Rezoning Transportation Analysis

Petition Number: 2020-046

General Location Identifier: Tax ID 20103128

Date	Description
04-21-20	First Review

Rezoning Site Plan

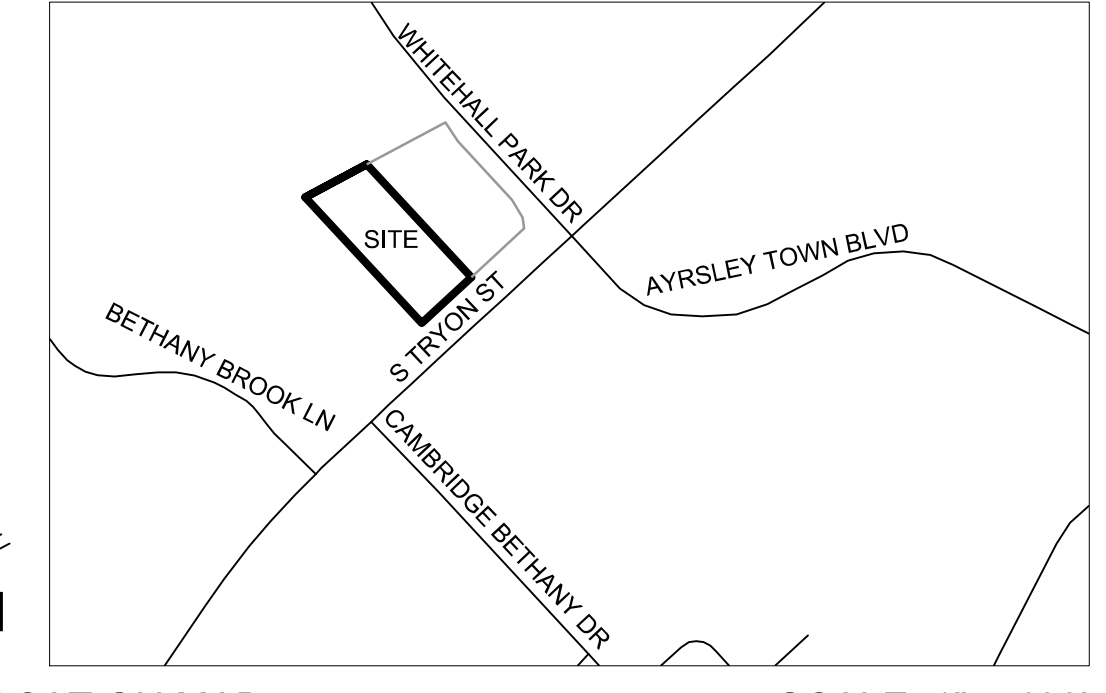
- Traffic Study** A Traffic Impact Study is not necessary for the complete review of this petition.
- The petitioner should revise the site plan and conditional note(s) to commit to dedicate a minimum of 35 feet of right-of-way from the Whitehall Park Drive road centerline, per the Chapter 12 Zoning Ordinance requirements for a minor thoroughfare. The site plan should label and dimension the right-of-way from the road centerline.
- The petitioner should revise the site plan and conditional note(s) to preserve the existing driveway as right-out only. Per NCDOT, a right-in/right-out driveway will affect the functionality of the intersection. Please provide CDOT with any other correspondence that the petitioner has had with NCDOT, since plans to convert this access to right-in/right-out were already submitted to the city for permitting review within Accela: LDC-2019-00062 - Leon Whitehall.

- In reference to the Urban Street Design Guidelines (USDG), CDOT recommends the petitioner to revise the site plan and conditional note(s) to decrease the Tryon right-out only radius for a SU-30 vehicle only, using Condition D of Appendix C of the USDG.
